Recommendation Report for Planning Permission

REF NO: LU/36/25/PL

LOCATION: 7 Roman Acre
Littlehampton
BN17 7HN

PROPOSAL: Construction of 1 No. 3 bedroom self-build house (resubmission following LU/187/23/PL). This application is in CIL Zone 4 and is CIL Liable as a new dwelling.

Job No: **MP-JD-RA** Drawing No: **PL01** Rev: **B**

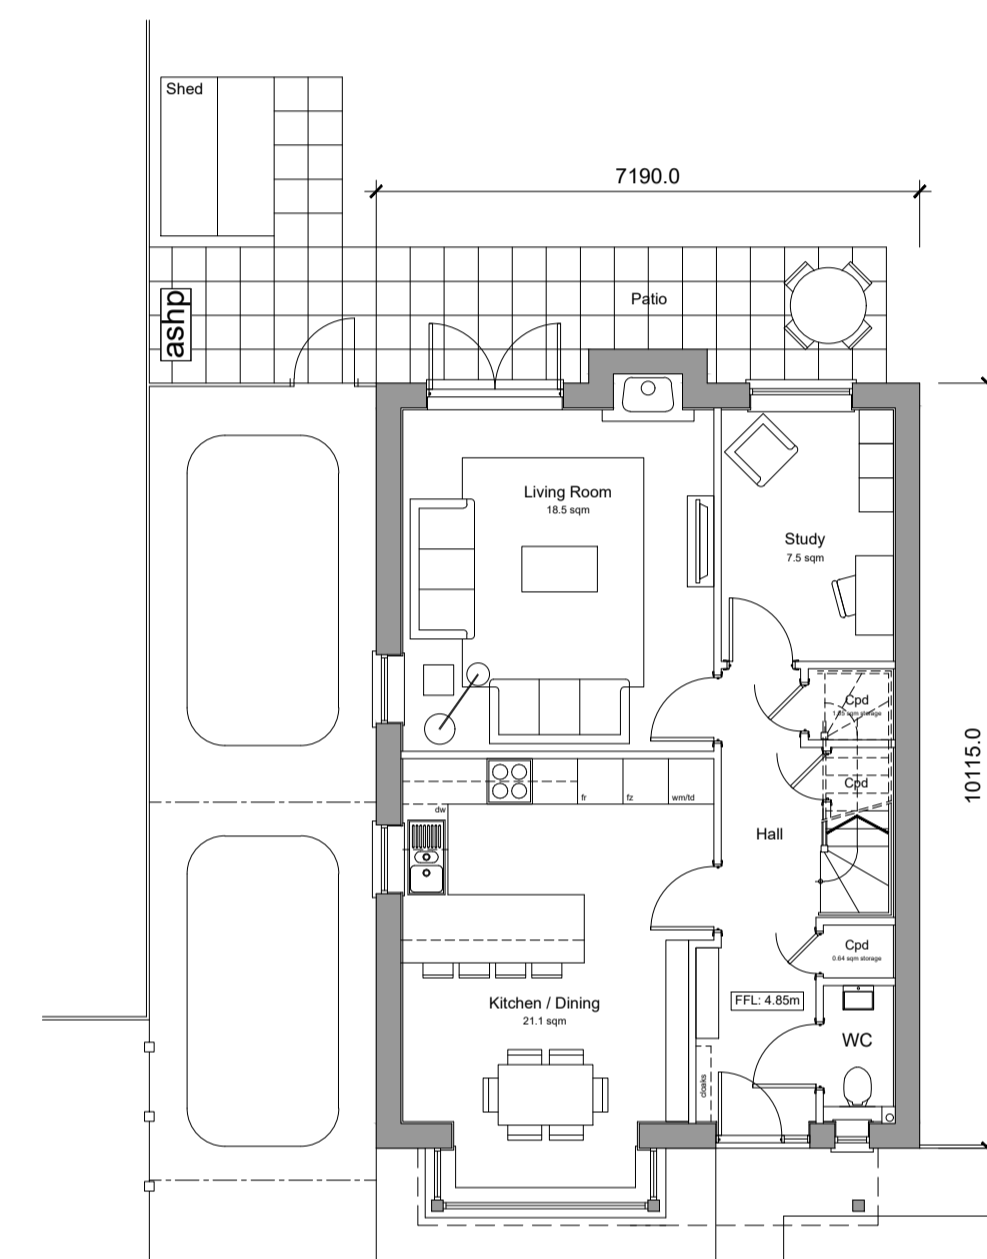
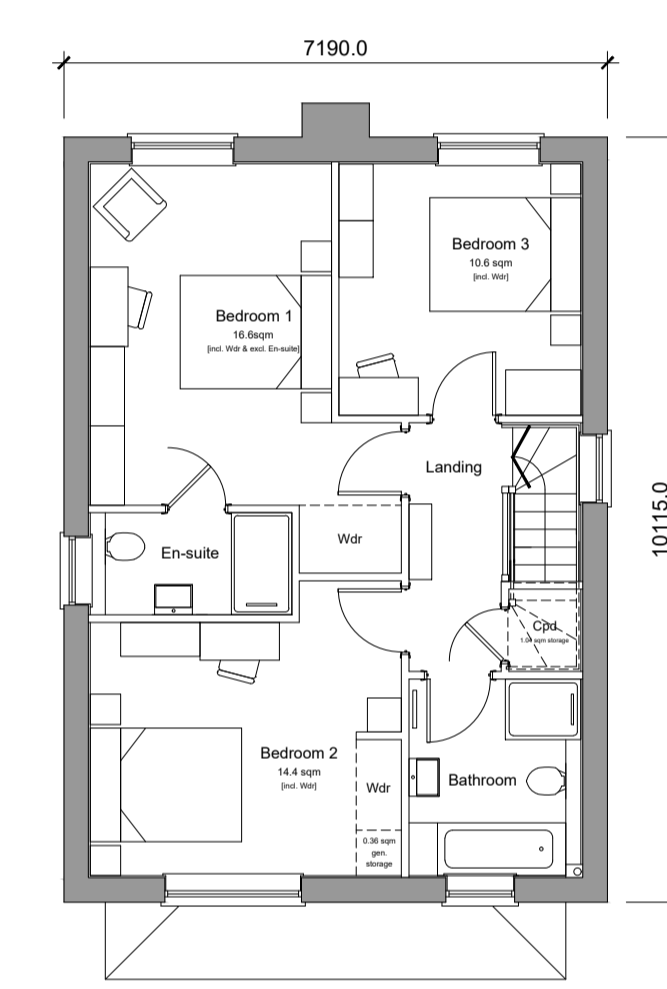
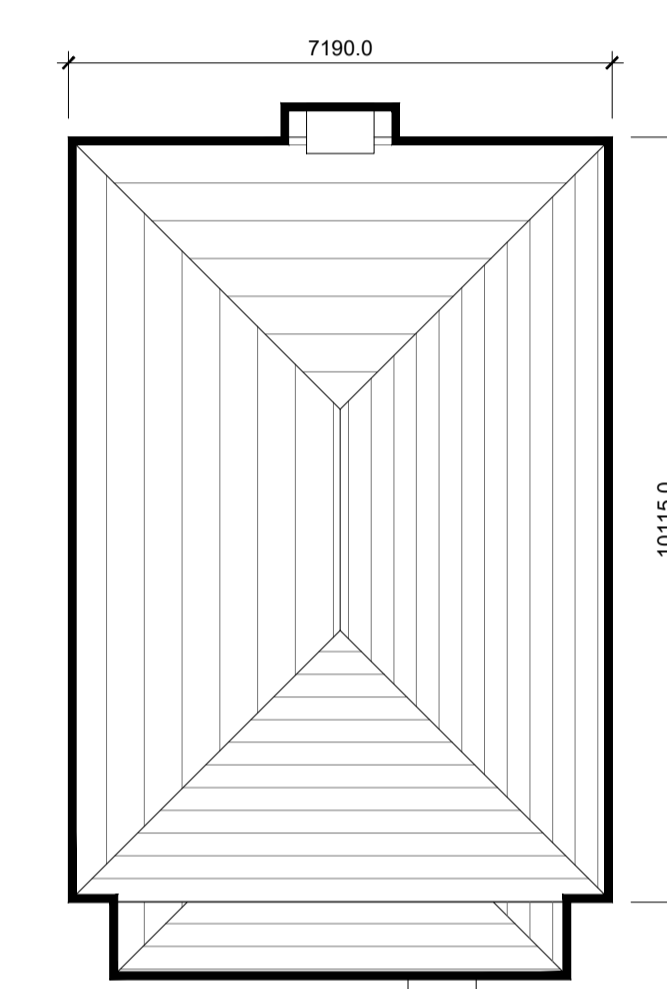
It is understood that in order to satisfy the relevant flood risk mitigation requirements, any future iteration of the proposal may require finished floor levels that are approx. 0.5m greater than proposed. Should any future design incorporate such higher floor levels, the proposal should include street elevations to understand how the design would relate to its neighbouring units, particularly No. 7 as this may have significant knock-on impacts to the height of fenestrations etc.

The 2 No. first-floor front windows serve a bedroom and bathroom. The northernmost of the two (bathroom) would be conditioned to be obscure glazed and non-opening to a suitable height. As such, its overlooking impacts toward the side and rear amenity space of No. 5 Roman Acre would be negligible.

The southern first-floor side window of the proposal serves an en-suite and would be conditioned as obscure glazed and non-opening to a suitable height to prevent direct overlooking of No. 7 and other neighbours immediately to the south.

The application has been supported by a Site-Specific Flood Risk Assessment that seeks to conclude that the proposed occupiers would be safe for the developments lifetime. However, the Environment Agency have provided 2 No. Objections to the submitted Flood Risk Assessment, concluding that it has not provided sufficient freeboard above the 0.5% event design flood level whilst also accounting for climate change. They note that latest guidance requires 600mm freeboard to be provided, and that the supplied FRA states that only 20mm has been provided for the new dwelling. Consequently, the development proposes inadequate finished floor levels including freeboard.

to reiterate a section of relevance to the applicant set out within the design section, it is understood that in order to satisfy the relevant flood risk mitigation requirements, any future iteration of the proposal may require finished floor levels that are approx. 0.5m greater than proposed. Should any future design incorporate such higher floor levels, the proposal should include street elevations to understand how the design would relate to its neighbouring units, particularly No. 7 as this may have significant knock-on impacts to the height of fenestrations etc.
